KITTITAS COUNTY COMMUNITY DEVELOPMENT SERVICES

Subject: Zipperer Short Plat Final (SPF-21-00002) – Staff Review and Request for Additional Information

Kittitas County Community Development Services (CDS) received the second Zipperer Final Short Plat (SPF-21-00002) survey on July 15, 2021. Final Short Plat application that are found to be complete must be processed and approved within 30 days of the submittal date. Kittitas County staff has completed the review of your final short plat survey submittal. As provided below, staff has the following comments, requirements, and/or revisions for your application that need to be addressed prior to final approval and signature of the final short plat mylars.

**ZIPPERER SHORT PLAT, SP-20-00005
 SPF-21-00002**

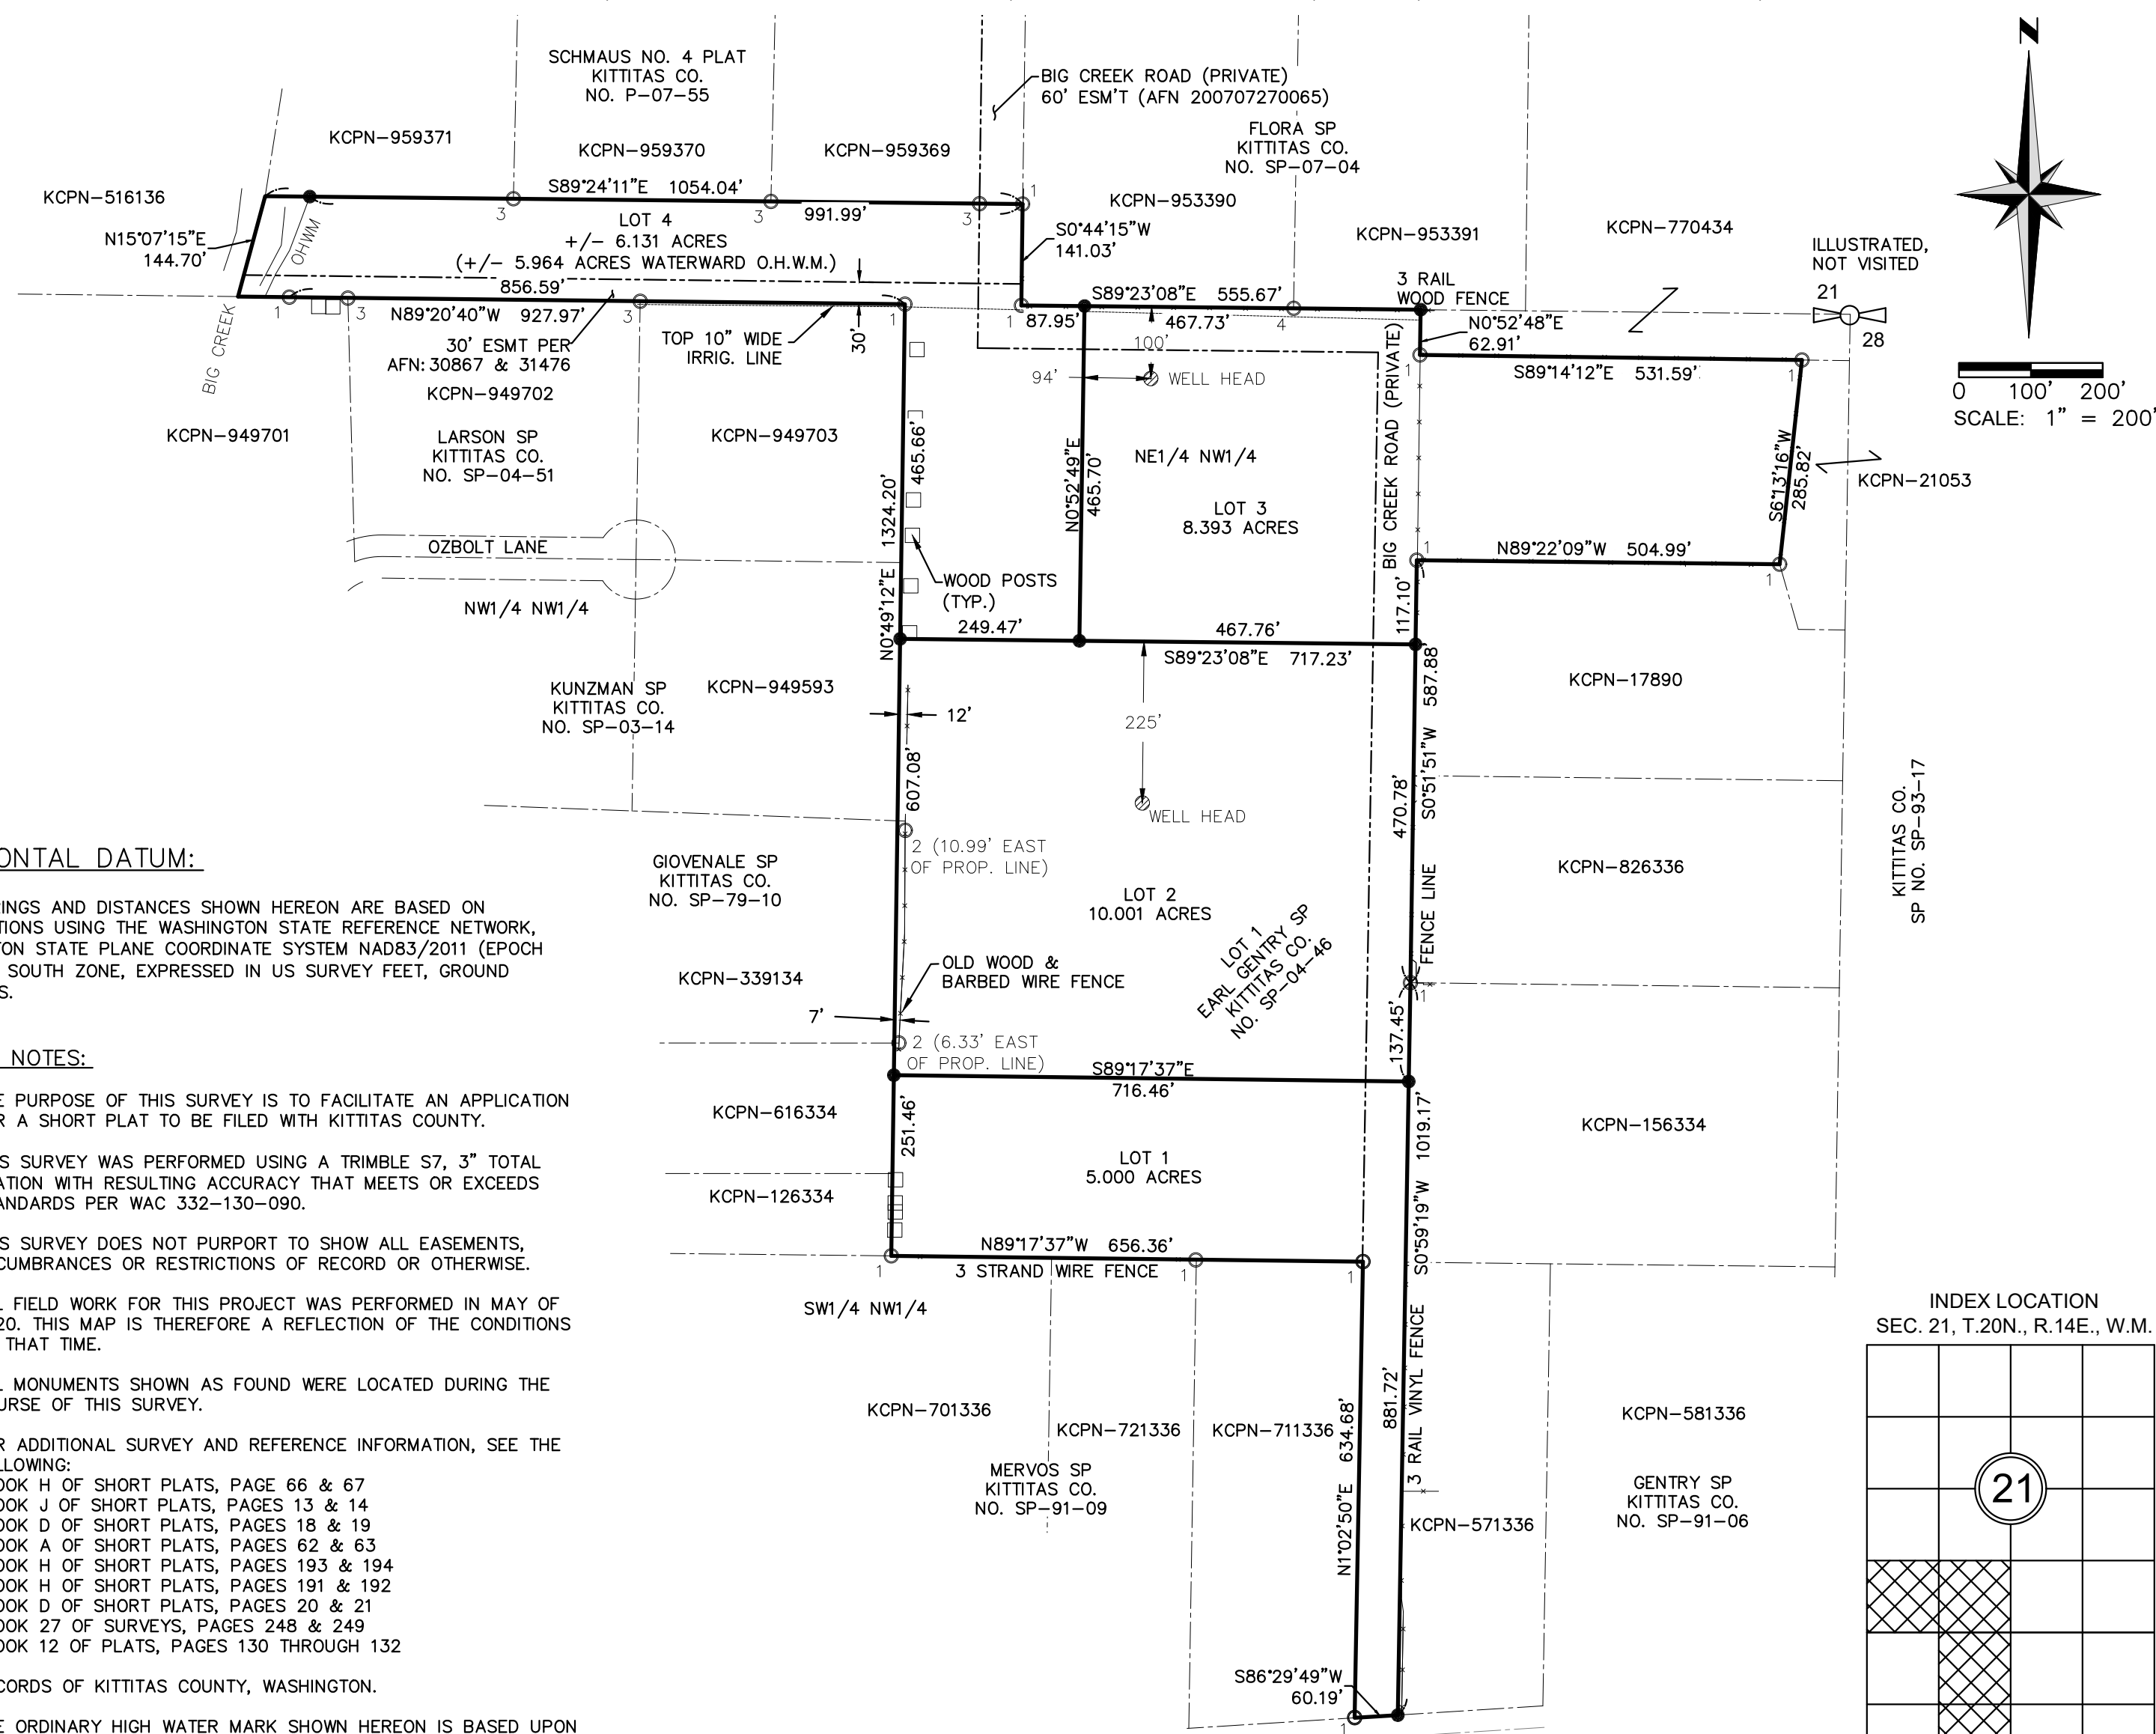
- o A Basis of Bearing statement needs to be included on the face of your short plat
